DECISION DELEGATED TO HEAD OF PLANNING

Application No: H03-0334-23 **Applicant:** Mr & Mrs Osbourne
Proposal: Garden room to rear of dwelling
Location: 23 Chappell Road Deeping St Nicholas Spalding
Terminal Date: 15th June 2023

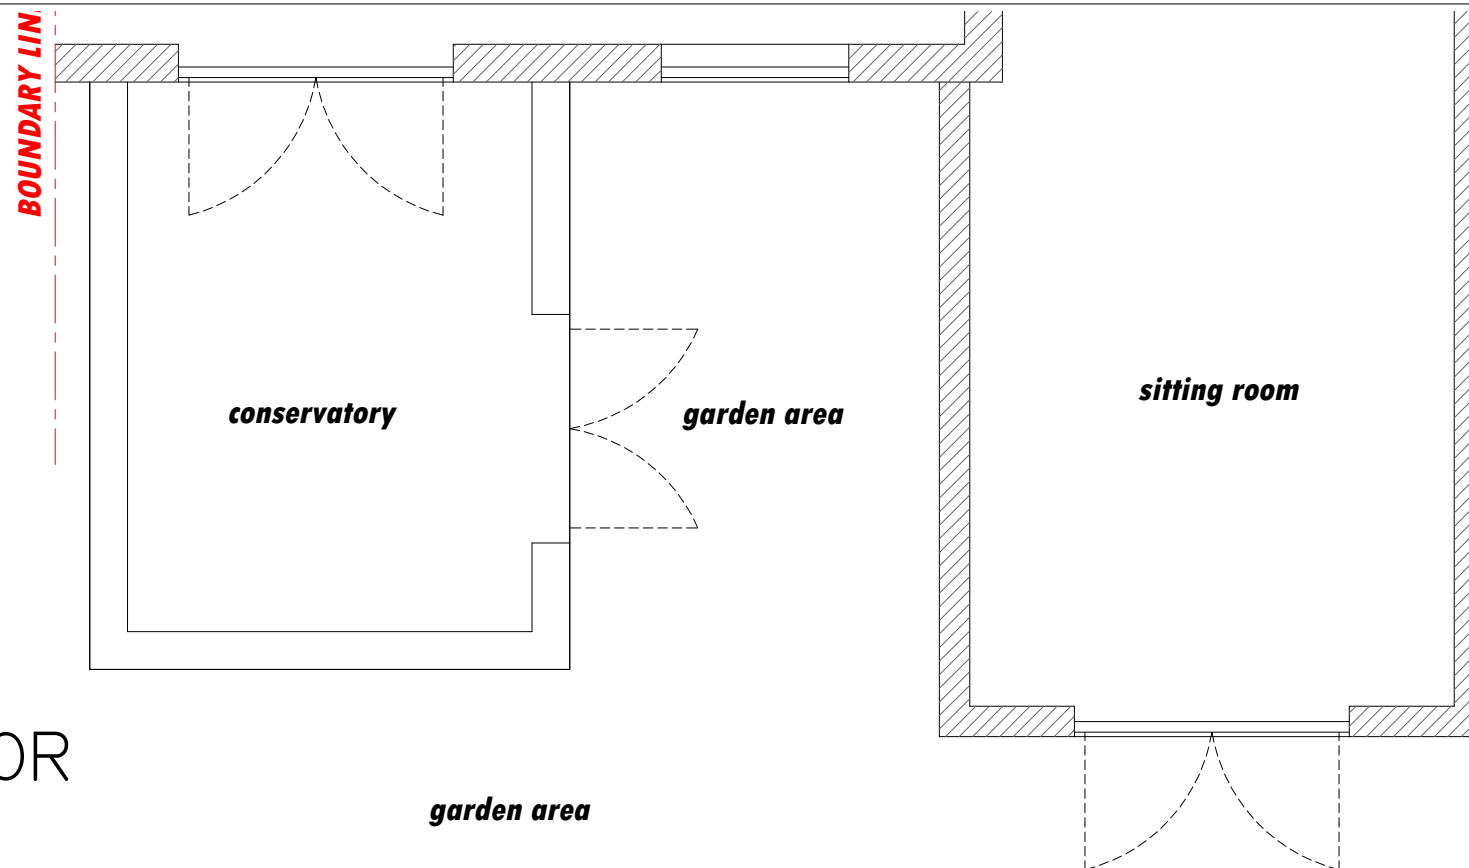
This is an application for a proposed garden room to the rear of 23 Chappel Road. The garden room is to measure 2500mm (depth) by 3000mm (width). Proposed is a mono-pitch roof, with the height to eaves measuring approximately 2450mm. The height to the peak would be 2600mm, in line with the existing flat roof extension.

DRAWING TITLE :
PROPOSED ELEVATIONS
1:100

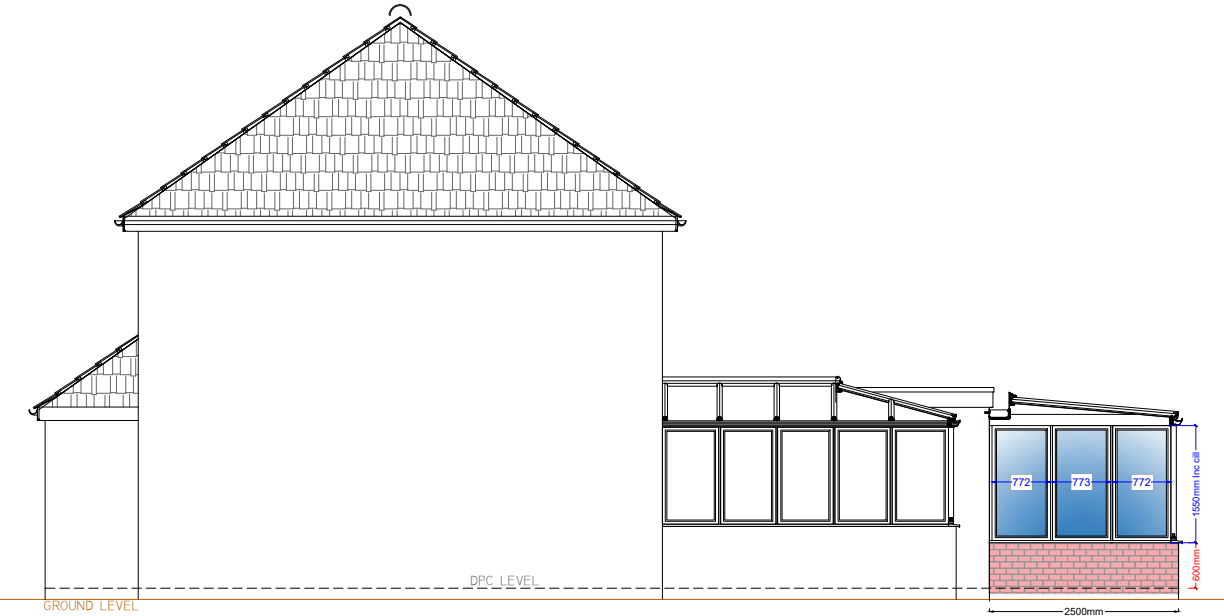
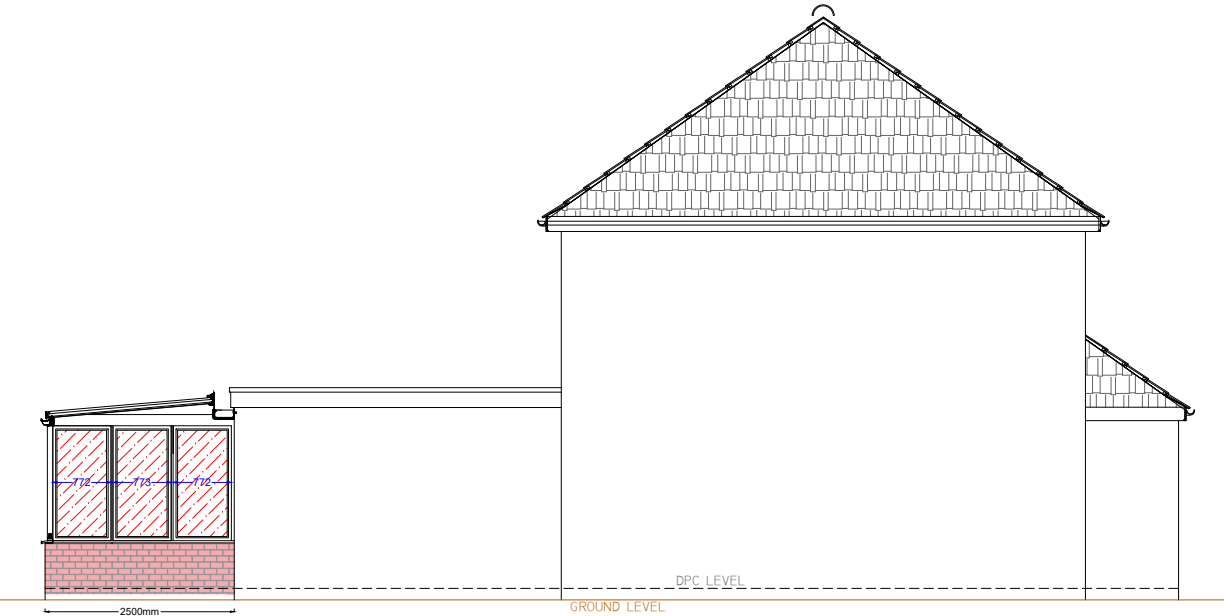
The brickwork of the proposed garden room would be consistent with the host dwelling. The windows and doors would also be consistent with the host, being of white PVCU. A polycarbonate roof is proposed.

The proposed materials (outlined above) would be in keeping with the character of the host property and the wider area. The brick work and frames would all match the existing property, ensuring the development appears well blended into the fabric of the house. While the polycarbonate roofing is not present on the host property currently, it is inline with what is to be expected from a development such as this. Furthermore, the roof would not be visible from the public realm, ensuring there is no damage to the street scene.

Present on site is a 2-metre-high boundary fence which, under condition 2 of H03-1319-03, must be maintained in perpetuity. This border treatment would prevent any overlooking or overshadowing via the development. The windows are below the height of the boundary treatment, and therefore, no overlooking could occur. The roof is to be made from a translucent material, ensuring that no overshadowing would occur.
